Transport
for NSW

CD13/05724

**SYDNEY INTERNATIONAL CONVENTION, EXHIBITION AND ENTERTAINMENT CENTRE
PRECINCT (SICEEP)
DARLING HARBOUR, CITY OF SYDNEY (SSD 5752 AND SSD 5878)**

ATTACHMENT 1

Figure 4-14 Amended Base Network

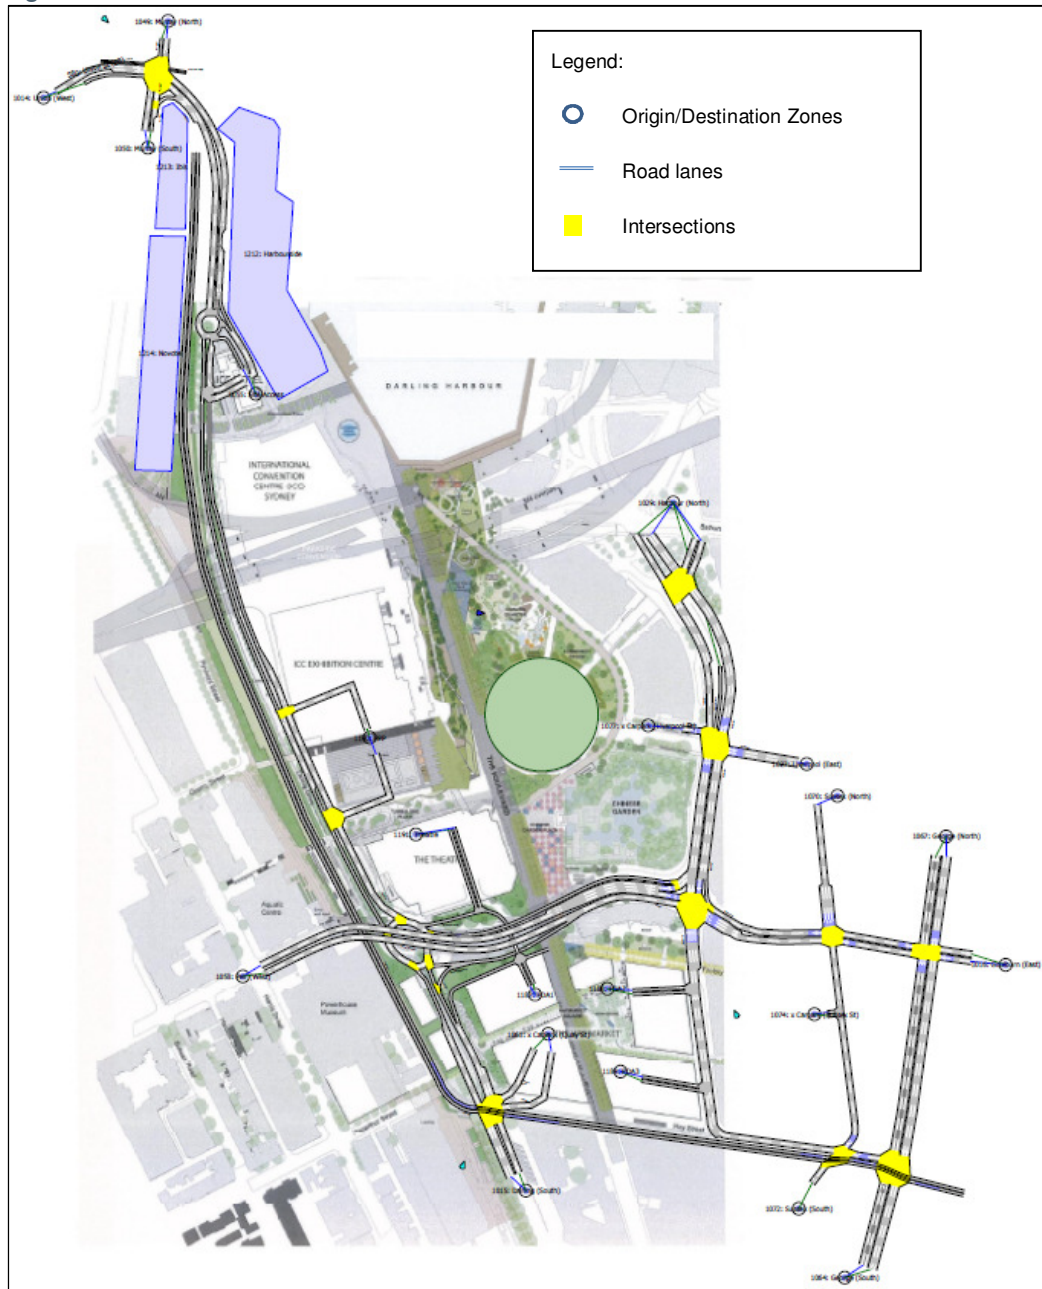
- The Aimsun Model Calibration and Validation is only based around GEH criteria. The calibration and validation ignores other criteria (as indicated within RMS's Traffic Modelling Guidelines) such as travel times and queue lengths. In addition, for simulation models, the guideline recommends detailed analysis of critical movements to ensure they do affect modelled outcomes. Therefore, Hyder will be required to demonstrate to the satisfaction of the RMS that the base Aimsun traffic model has been suitably calibrated and validated against all agreed key criteria within RMS's Traffic Modelling Guidelines – RMS 13.184. This document can be downloaded at the following link:

For one of the GEH criteria (Links with difference in flow within 15% for flows between 700 and 1700vph) - The target required is 85%. Yet on the Friday PM peak they only reach 64%. The report then explains the following: *"Large traffic flow difference is observed at Goulburn Street / Sussex Street and Sussex Street / Hay Street due to upstream and downstream congestion. However, it does not impact on the study area"*. This would be acceptable to RMS on the proviso that Hyder can clearly demonstrate that their model reflects conditions outside the study area, if such impacts are felt within the study area.
